Application no: H08-0241-15

Description: Erection of detached bungalow and garage - approved under H08-0968-14. Modification of Condition 2 to allow amendments to approved plans.

Location: Rear of 59 High Street
Gosberton
Spalding
Lincolnshire
PE11 4NJ
PE11 4NJ

Amendment: First floor side windows removed (dwg. nos. 2470-001B, 2470-002C and 2470-003B)

Date	Contract No	Org No
26.02.15	2470	003B

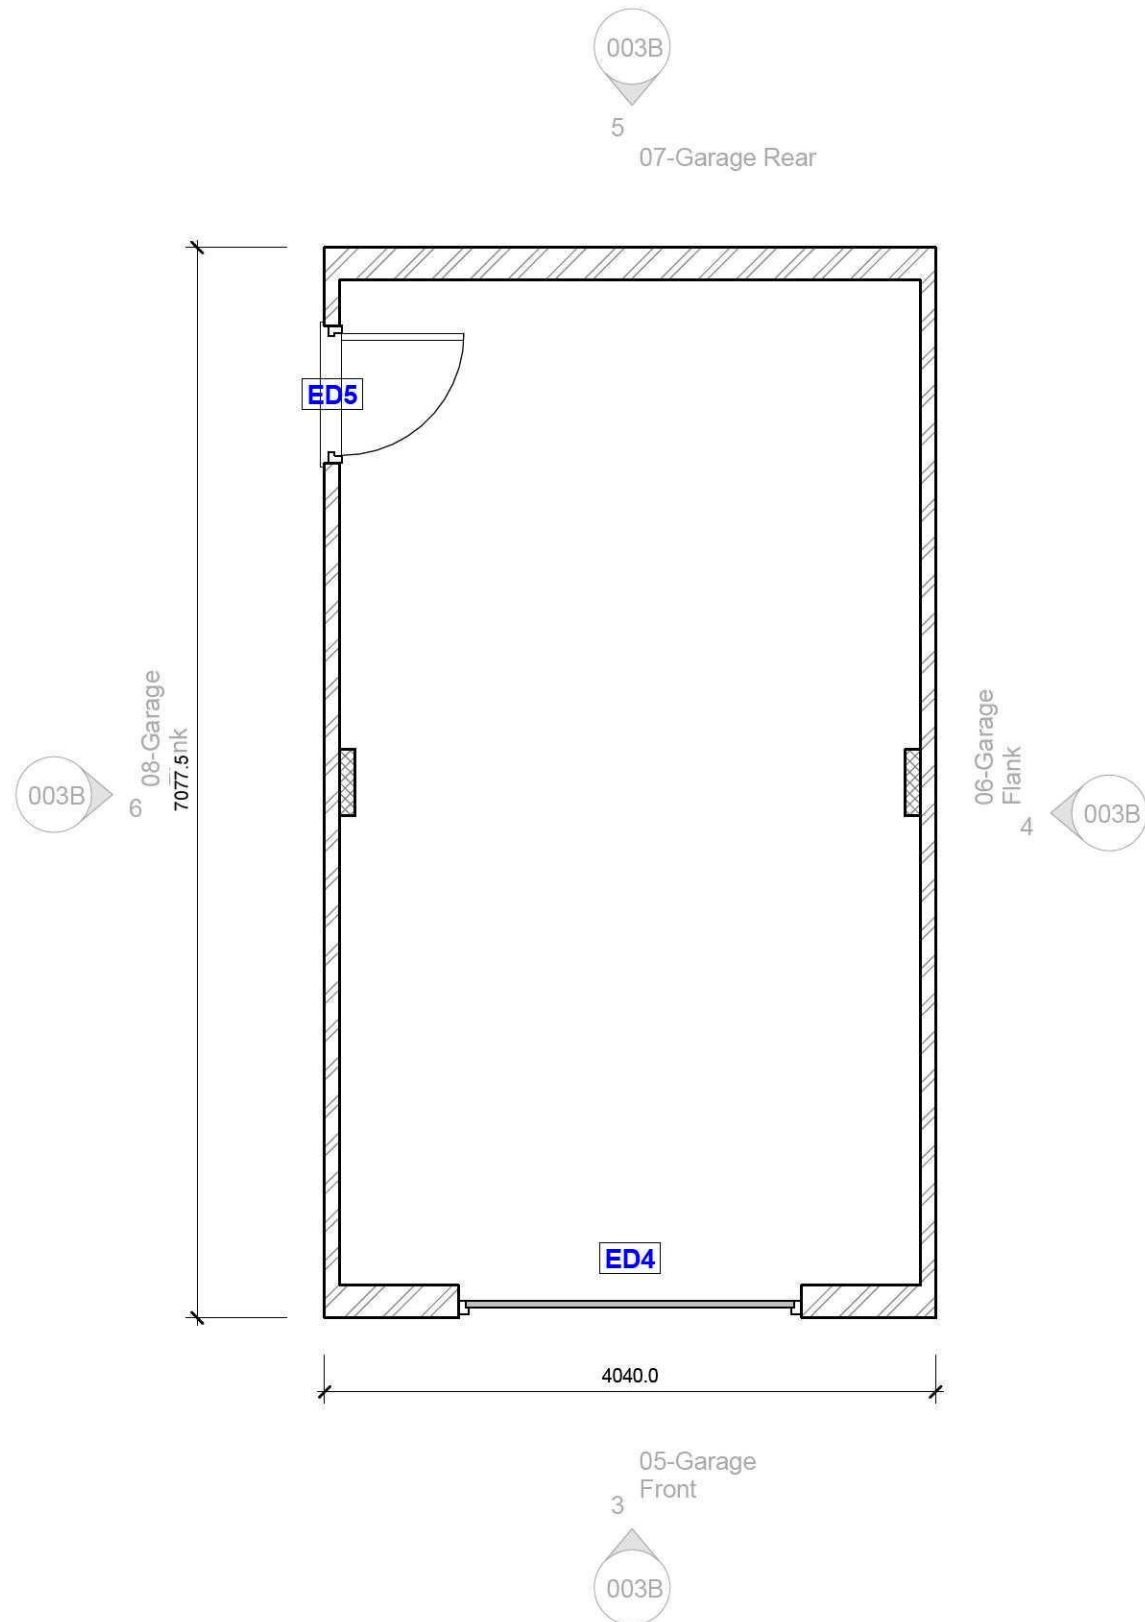
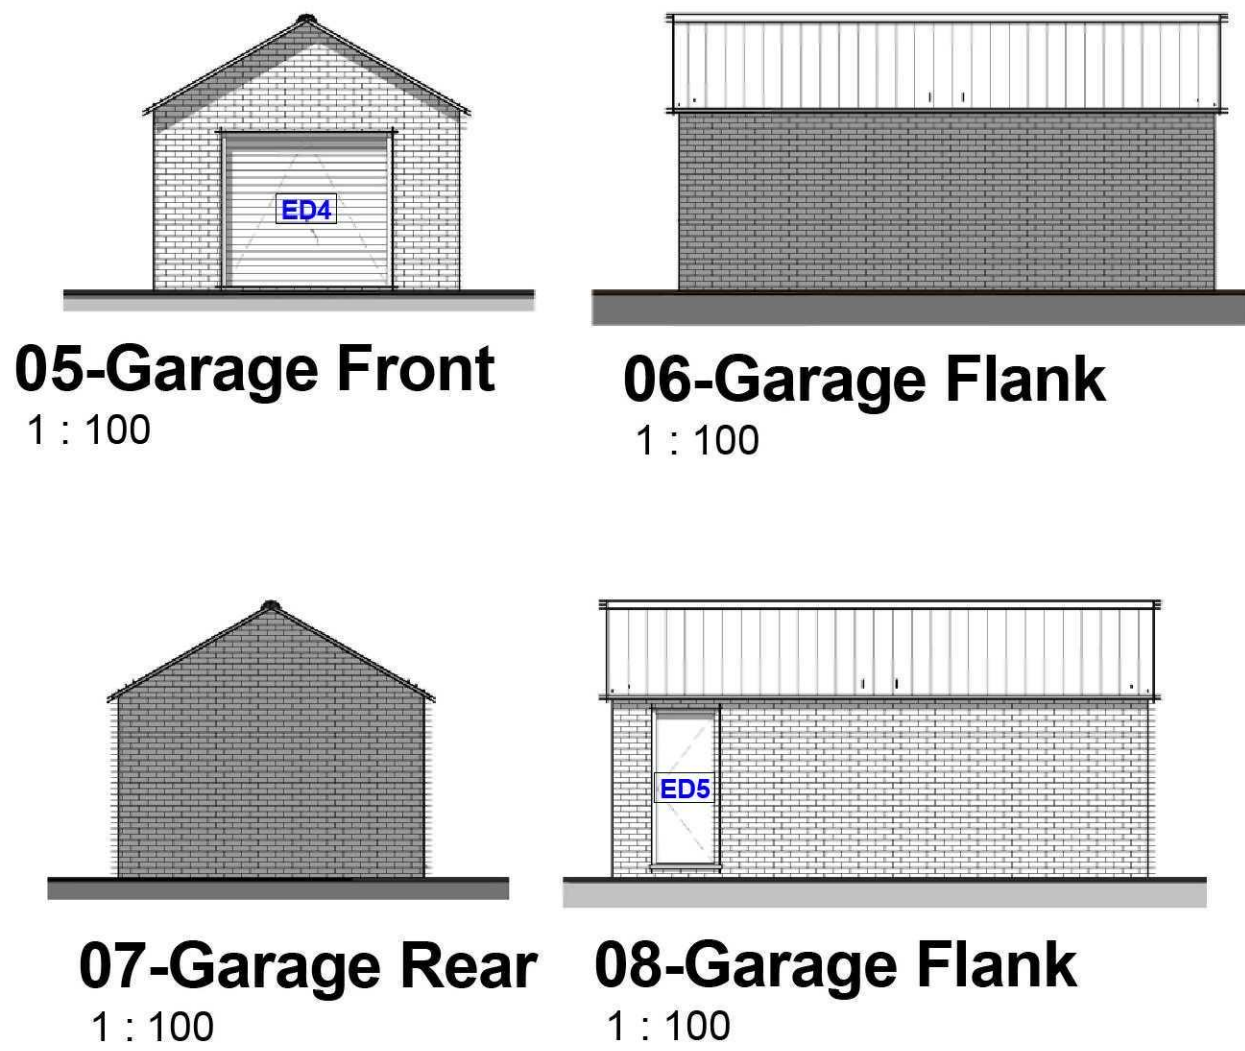
Regarding the amendment for 59 High Street, Gosberton, could you also submit amended plans 001 and 003 to include the changes to the windows.
